Ribble Valley Borough Council
Council Offices
Church Walk,
Clitheroe
Lancashire
BB7 2RA

Phone: 0300 123 6780
Email: developeras@lancashire.gov.uk
Your ref: 3/2025/0895
Our ref: 3/2025/0895/HDC/KW
Date: 09 December 2025

Location: Barn and outbuilding adjacent to Leagram Mill Farm Dinkling Green Lane Chipping PR3 2QS
Proposal: Conversion of existing barn and outbuilding to create a 4 bedroom dwelling with detached dwelling, including alterations to fenestration, insertion of rooflights, insertion of flue and associated landscaping, parking and private amenity space.
Grid Ref: 363862 444145

Figure 3.1 : Proposed Site Access Arrangement

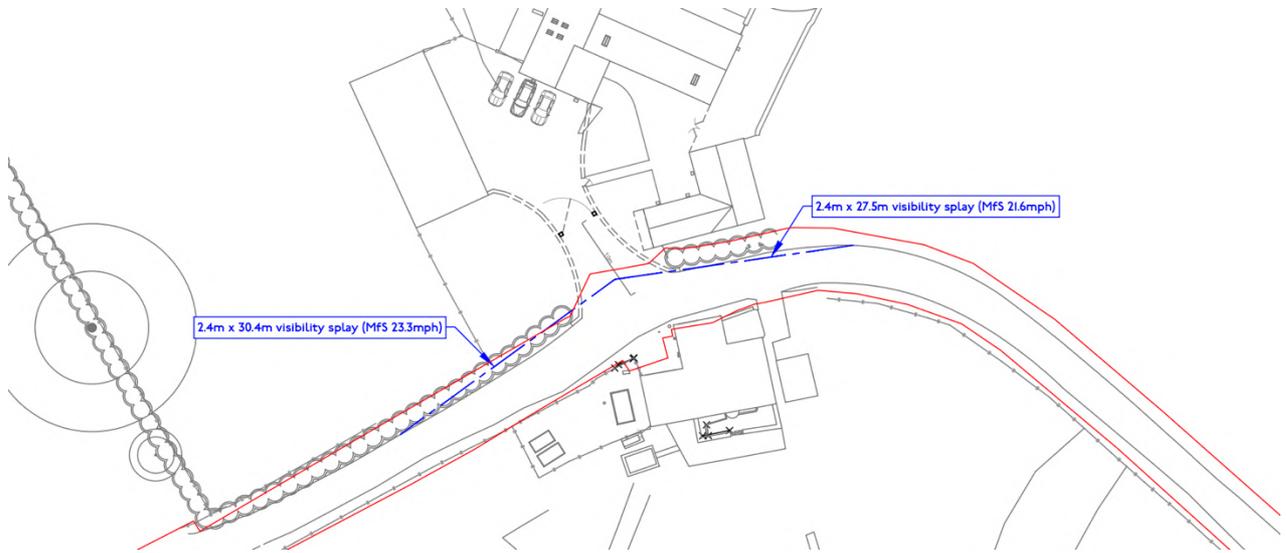
The proposal will generate more car movements and drivers will not have the same clearance over vegetation as the existing agricultural vehicles using the site. As such to ensure adequate intervisibility between highway users at a new access a visibility splay set 2.4 metres back from the near edge of the carriageway and extending 214 metres along the nearside carriageway edge in both directions should be provided.

Further amendments are required in regard to the access; the proposed gates should be set further back into the site at 10m behind the carriageway edge. This is because the site will provide access to an agricultural building and as such, agricultural vehicles and trailers require further space to pull clear of the carriageway. The access shall be paved in a permeable hardstanding material for 10m into the site to prevent debris from being dragged onto the highway and drainage, collected within the site and drained to a suitable internal outfall, should be provided at the access point to prevent water from discharging onto the highway.

Project Name Leagram Mill Farm	Project No. 210.24	Stage Planning Submission
Proposed Site Plan 07	Scale 1:200 @ A1	Date September 2025
Rev. A	Drawn	RP

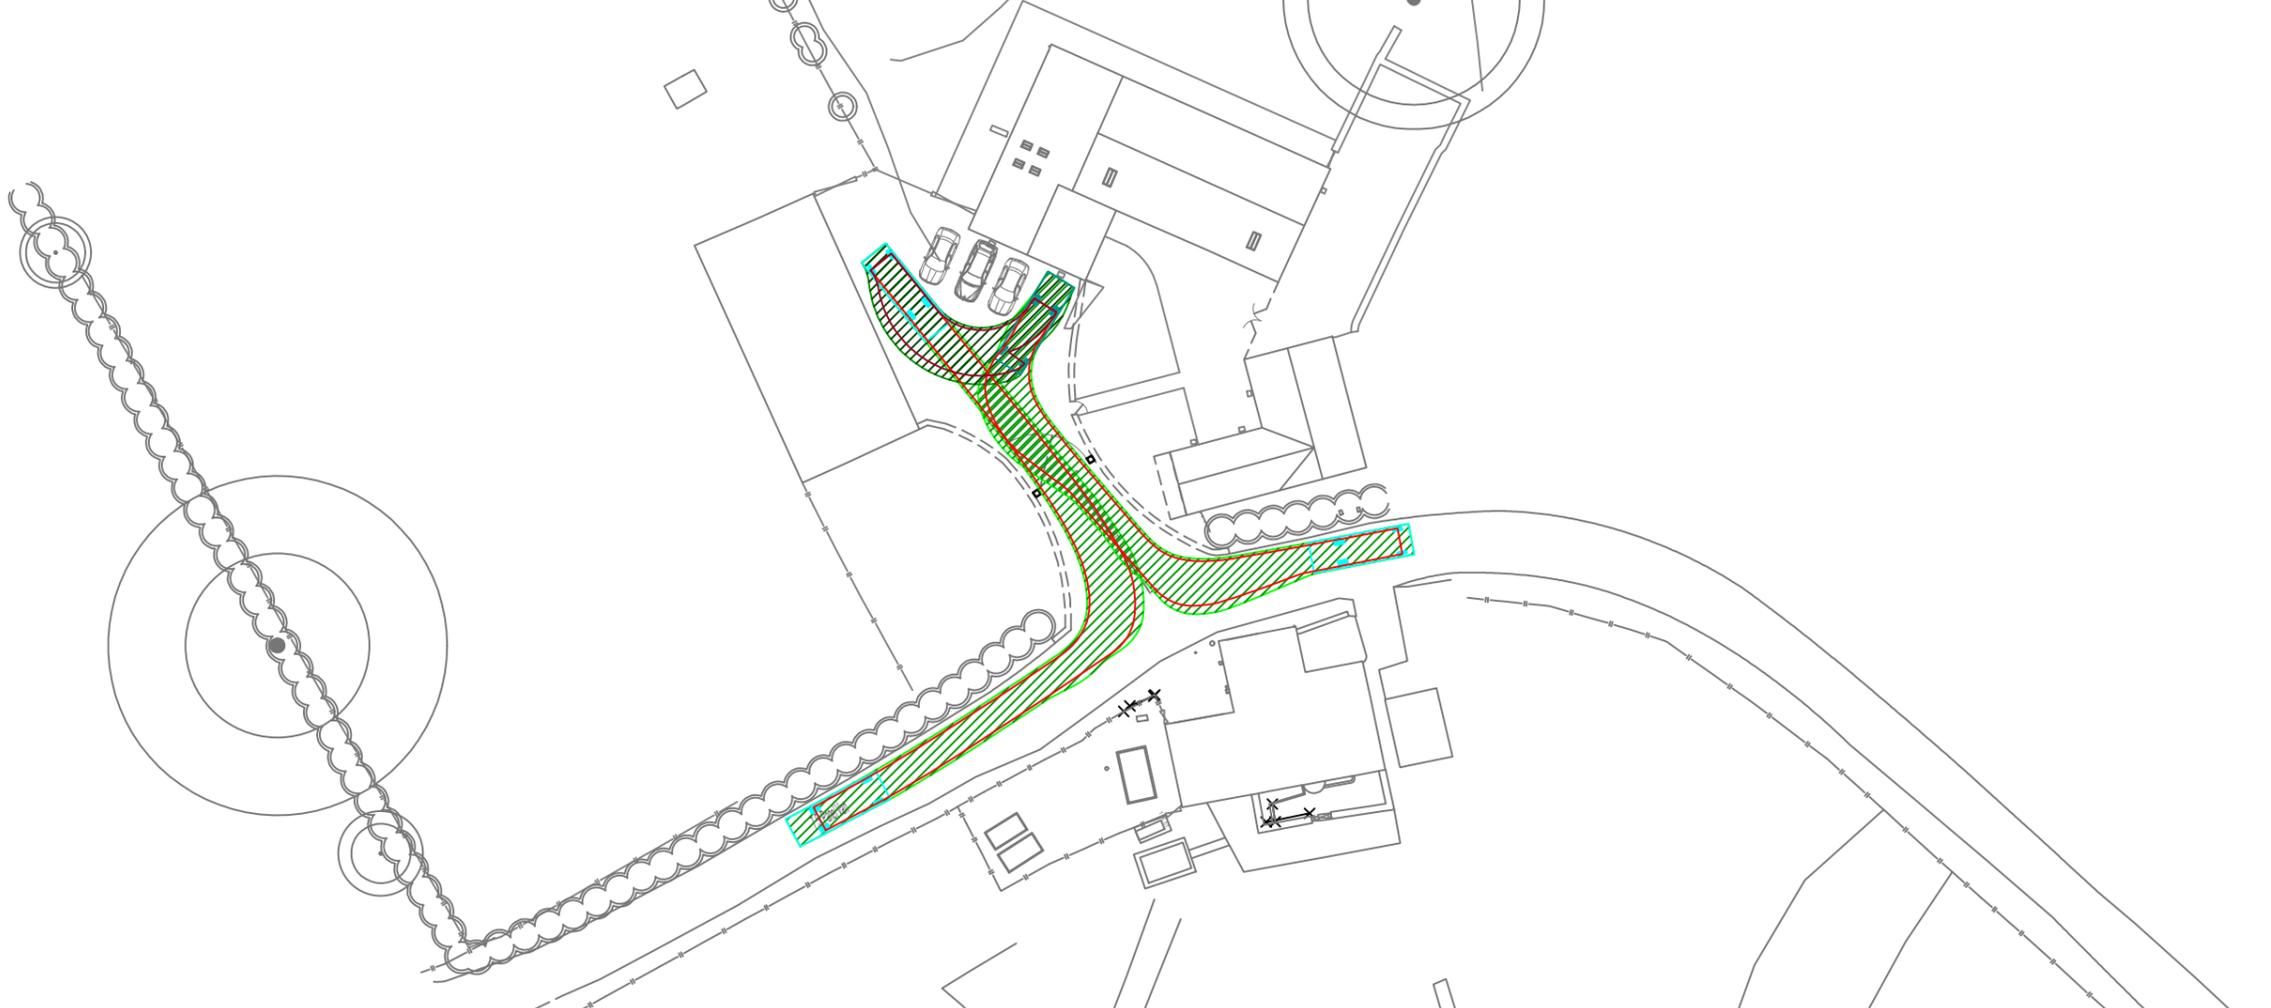
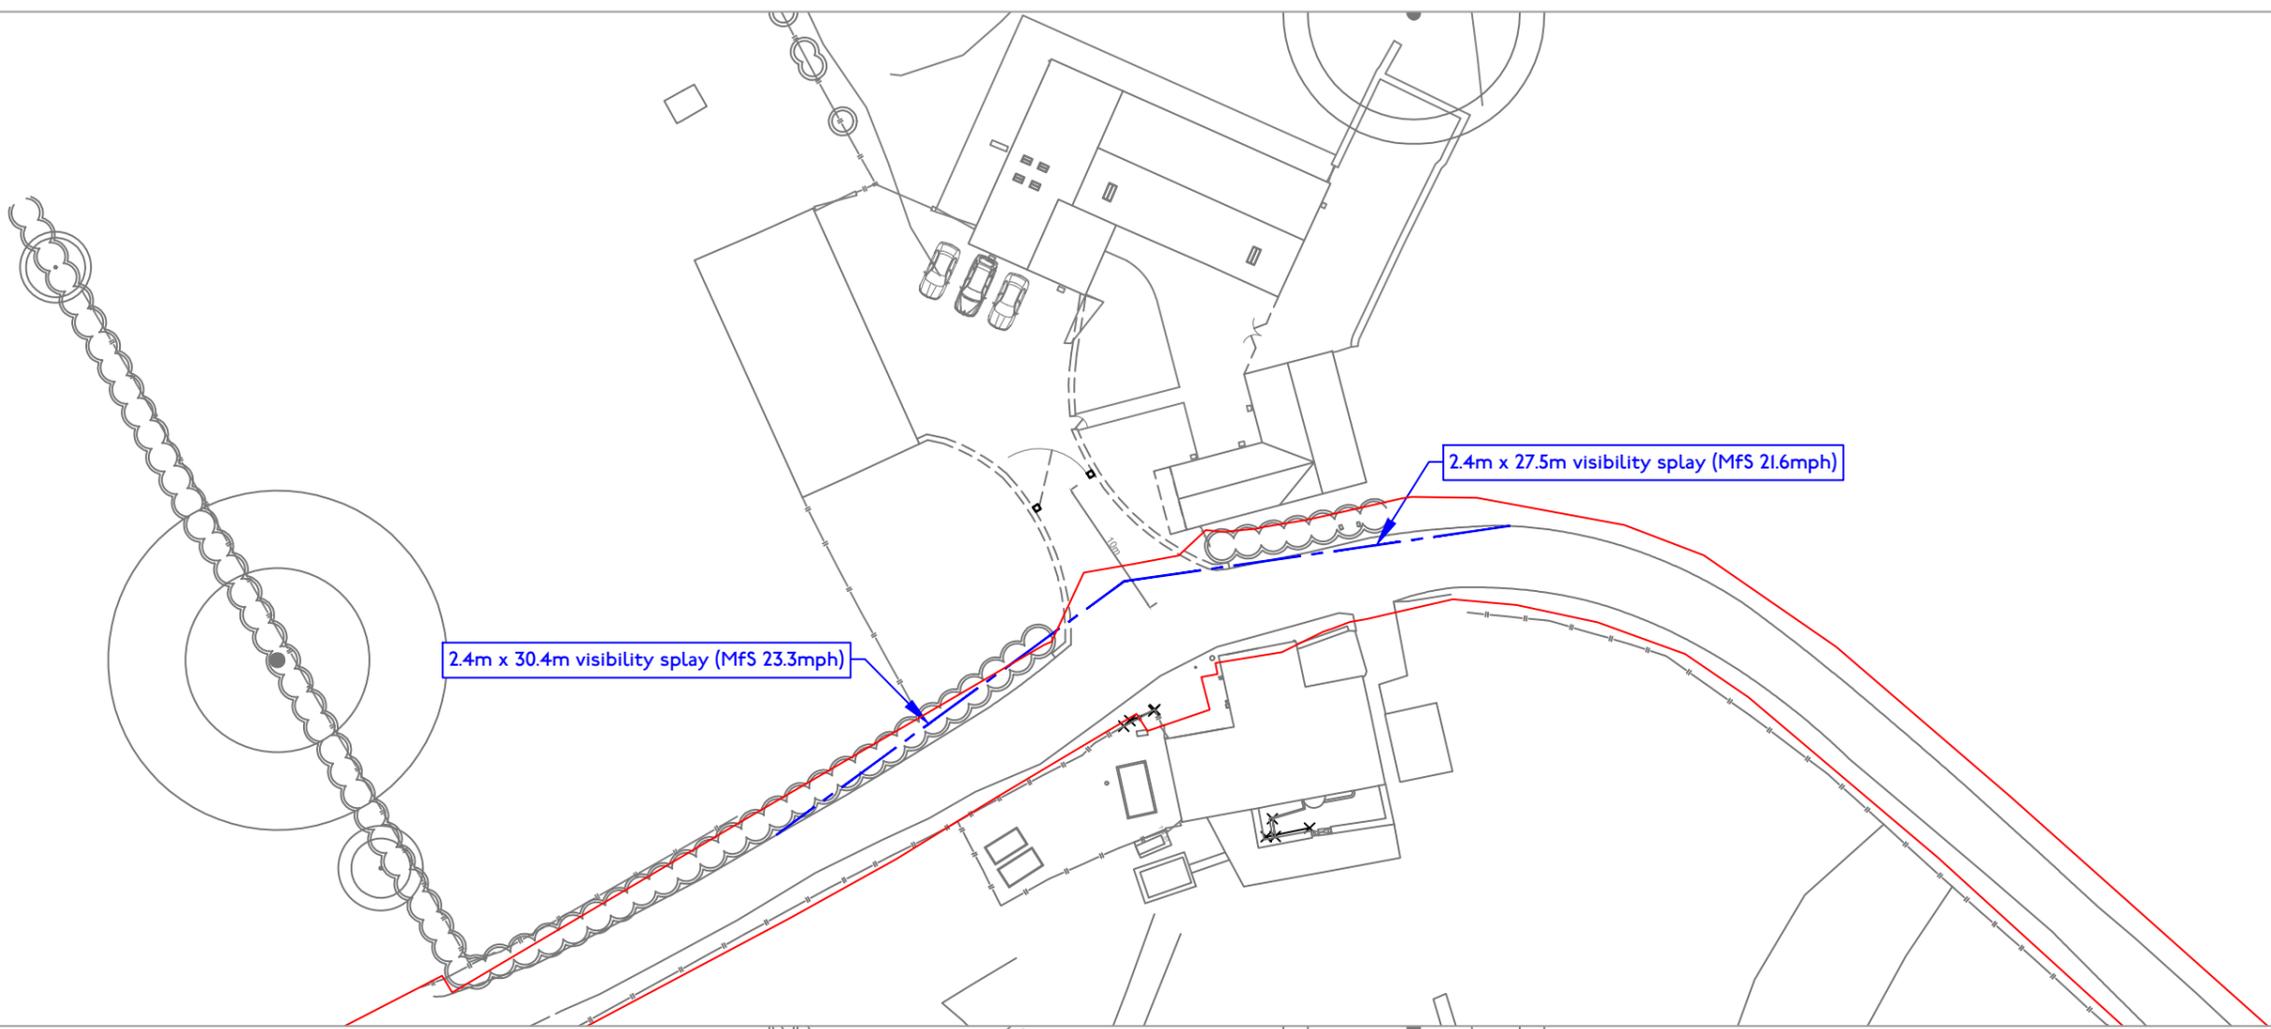
The site will be accessed via an amended existing access onto Dinkling Green Lane, classified as the C567, subject to a national speed limit. The access amendments include widening the existing access point to approximately 11m, the placement of a boundary wall around the access and gates set back approximately 9.5m.

The visibility splay should be wholly within the land which the applicant controls and/or the adopted highway and nothing shall be erected, retained, planted and / or allowed to grow at or above a height of 0.9 metres above the nearside carriageway level which would obstruct the visibility splay of the proposed access.

Or alternatively, reduced sight lines may be acceptable if the applicant can provide an observed traffic speed study, which indicates the 85th percentile traffic speeds are less than detailed above. The traffic study would need to be carried out by an approved specialist showing the 85th percentile wet road traffic speeds in both directions, the numbers of vehicles, types of vehicles and the speed of vehicles passing the access.

The applicant should provide accurate details of the required sight line requirement, before determining the application.

To conclude, the LHA has identified several matters that require further clarification and amendment before the application can be fully assessed. Including detailed visibility splays and the positioning of the gates at the site access.
